Development Control
Ribbles Valley Borough Council

App no: 24.0530

Address: Barn at Cockshotts Farm Stubbins Lane Sabden

Proposal: Proposed conversion of barn to two two-storey, three-bedroom dwellings and one three-storey, four-bedroom dwelling with associated landscaping, outbuildings and parking

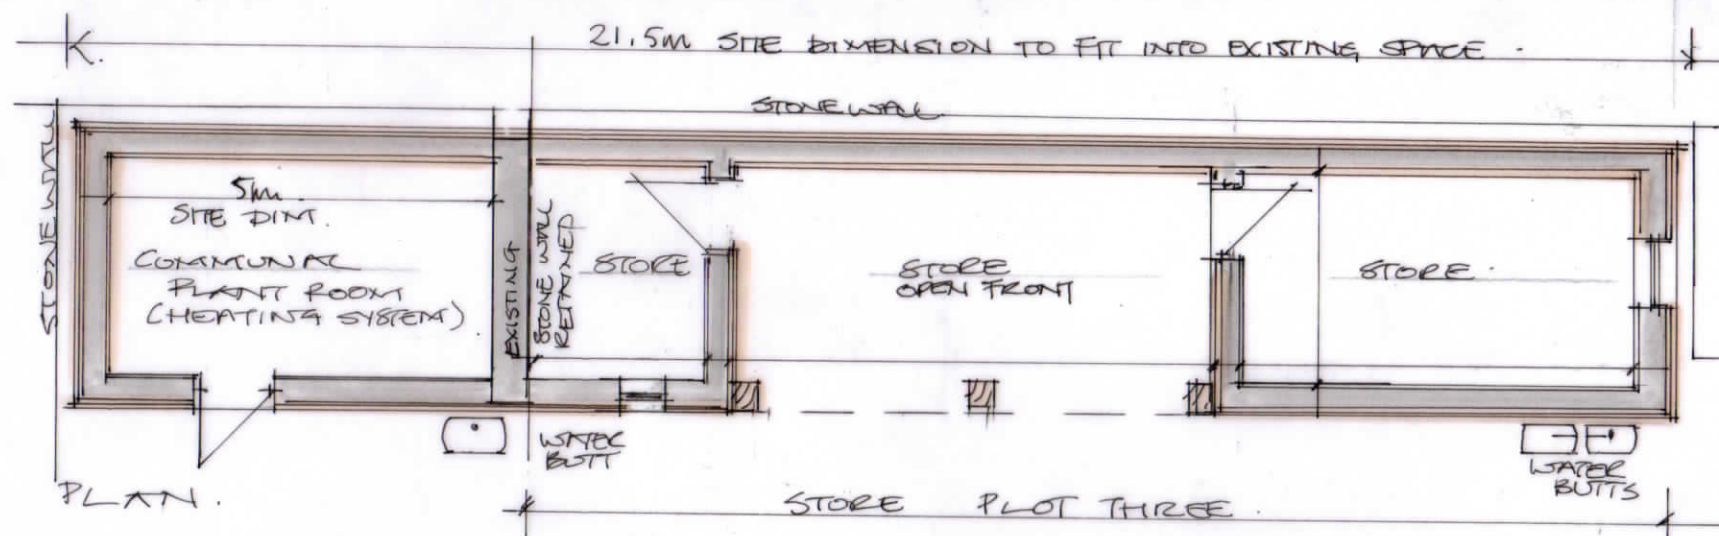
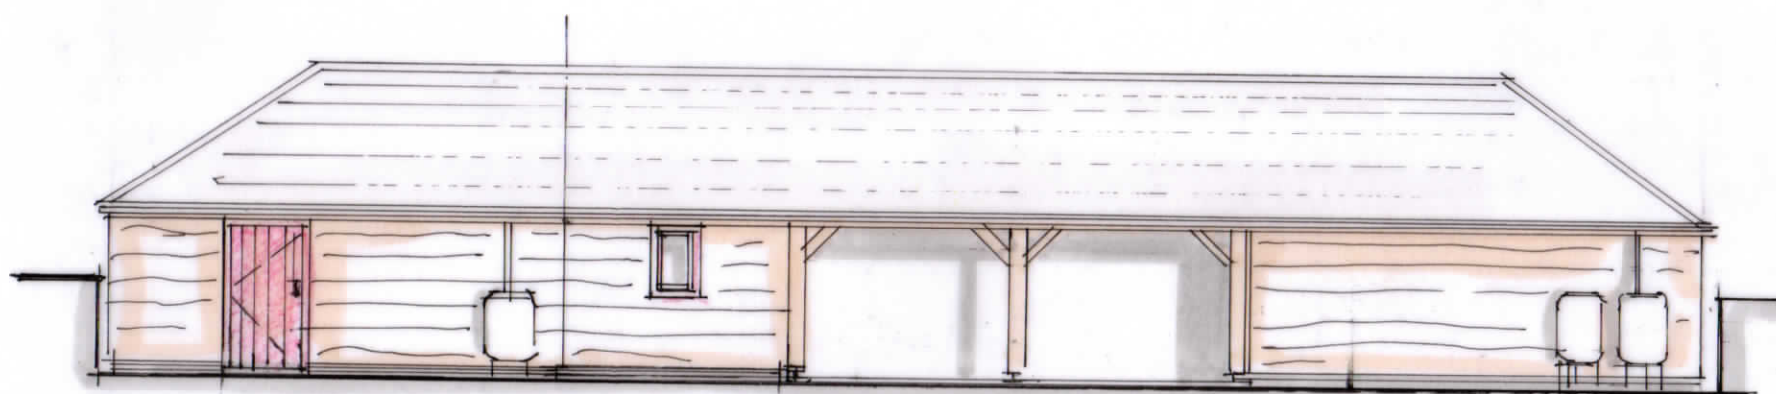
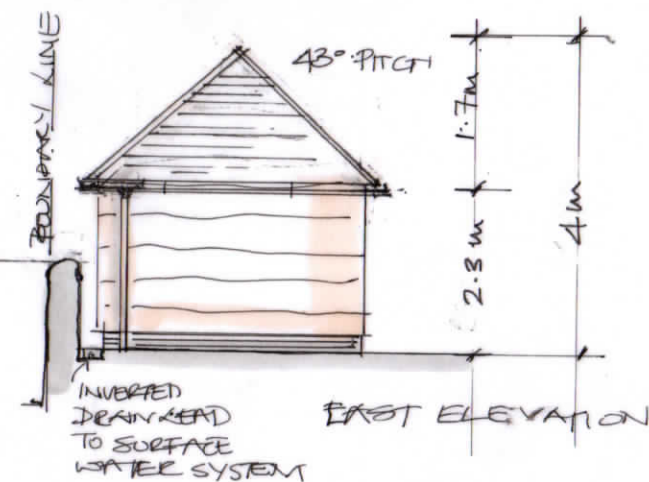
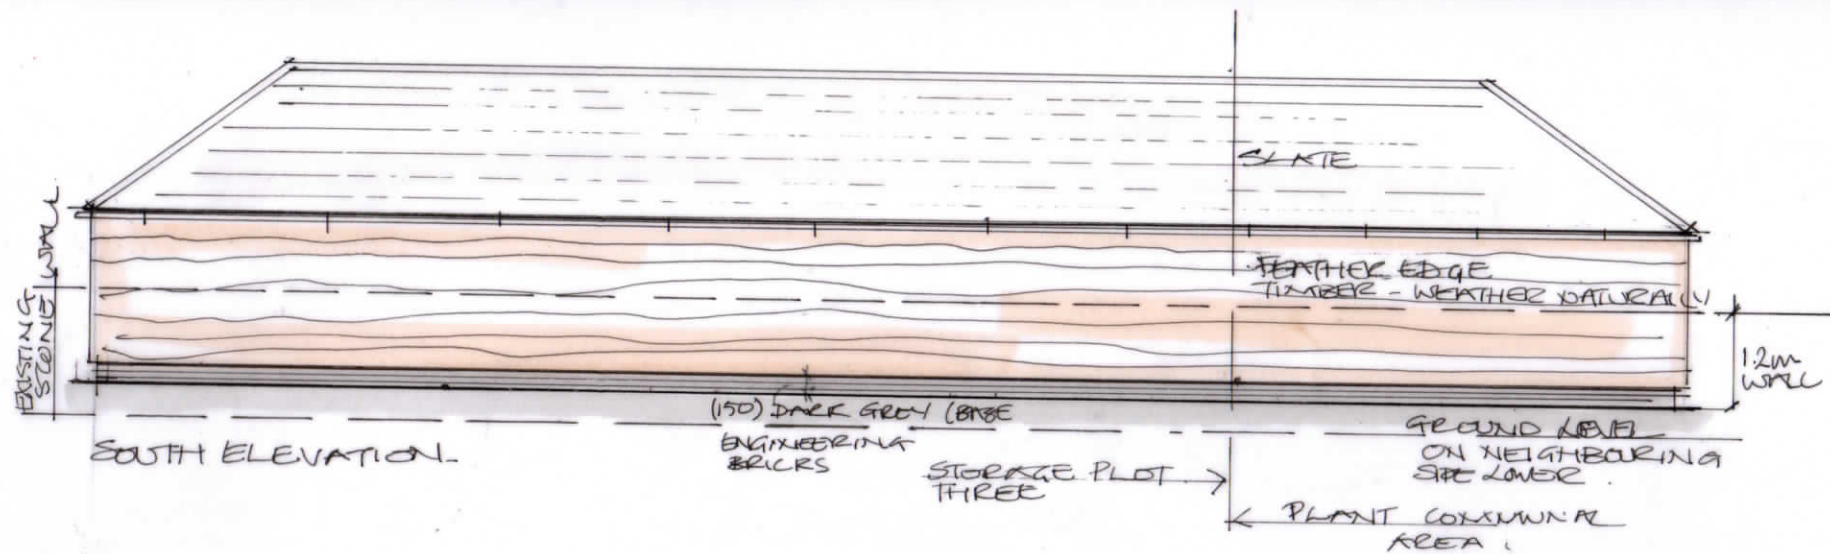
The cycle parking appears to be an external Sheffield stand. This needs to be replaced with a secure and covered cycle store for each dwelling.

3. Prior to first occupation each dwelling shall have a secure and covered cycle store for at least 2 bicycles. Reason: To support sustainable travel.
